MEMORANDUM

TO: Jean Fraser
FROM: Dan Goyette, PE
DATE: November 13, 2008
RE: 355 Warren Avenue

Woodard & Curran has reviewed the Application for Site Plan Review for 355 Warren Avenue in Portland. Stormwater drainage improvements are proposed in the "tow yard" including two new catch basins, a new drain manhole and 158 feet of storm drain. The project includes associated grading.

**SITE PLAN**

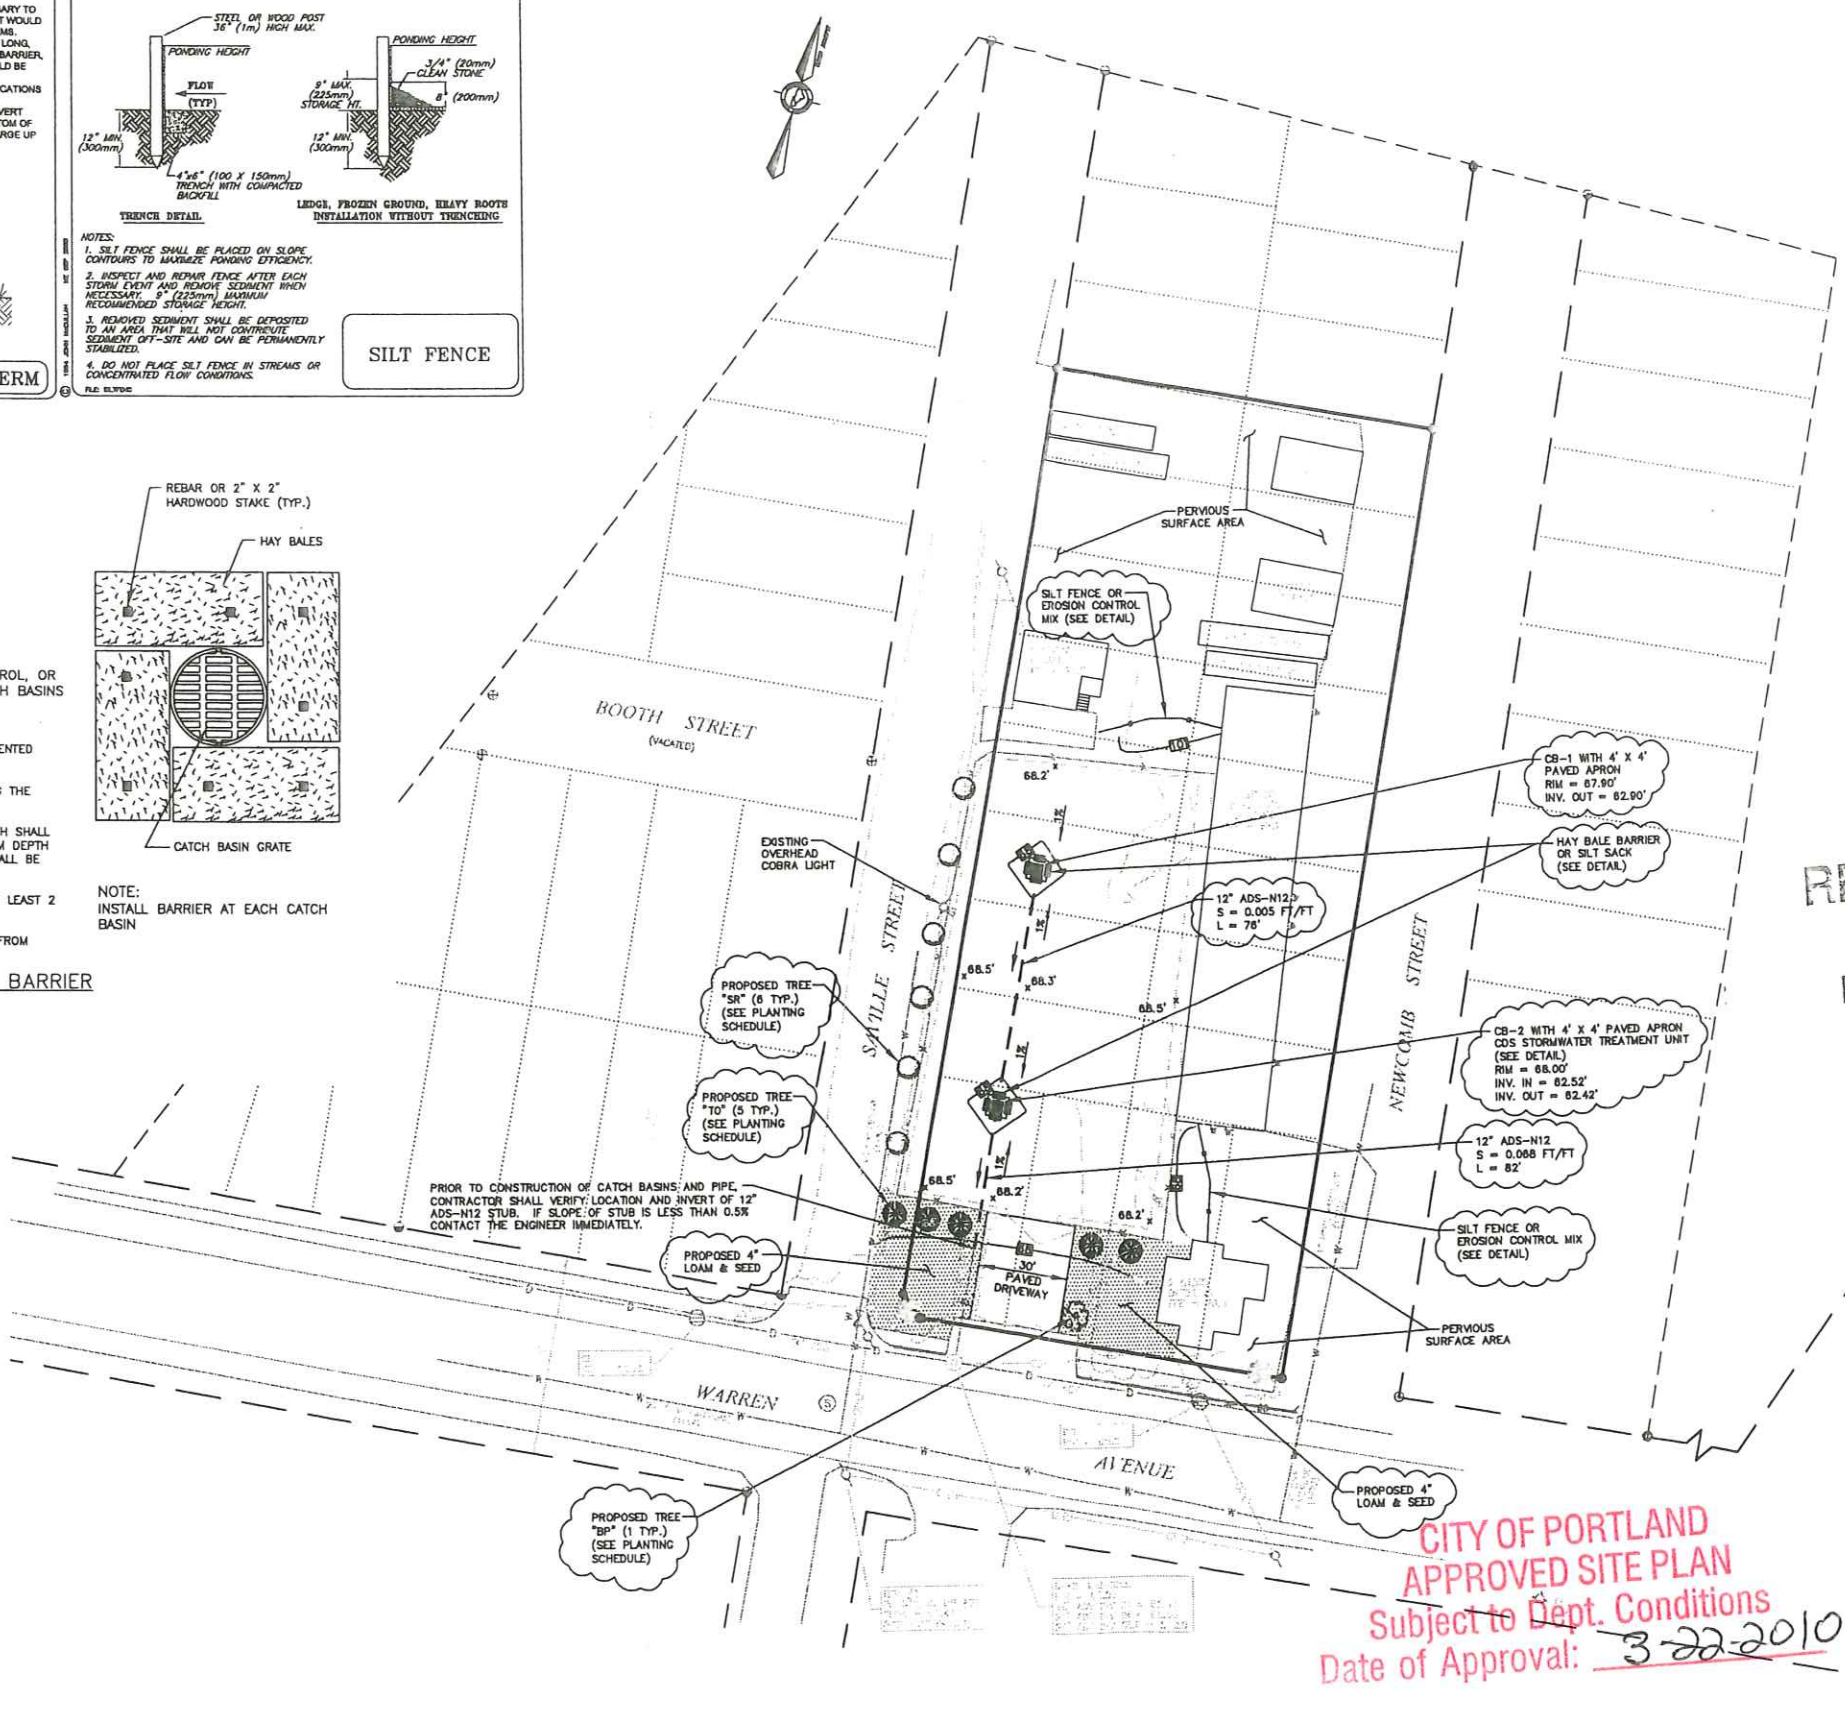
- The applicant should confirm that the survey for the project coincides with approved City standards. The applicant states that this requirement has been waived but we are not aware of any such agreement. If there is not an agreement, the survey needs to be tied to the vertical datum of NGVD 1929. Also, the project needs to be tied to the Maine State Plane Coordinate System (2-zone projection), West Zone using the NAD 1983 (HARN) Datum and the U.S. Survey Foot as the unit of measure. This should be indicated on the survey.
- Erosion Control Measures have not provided.
- The manhole detail shows only RCP while the plans show ADS N12 pipe. ADS N12 pipe is not allowed within the City Right-of-Way.
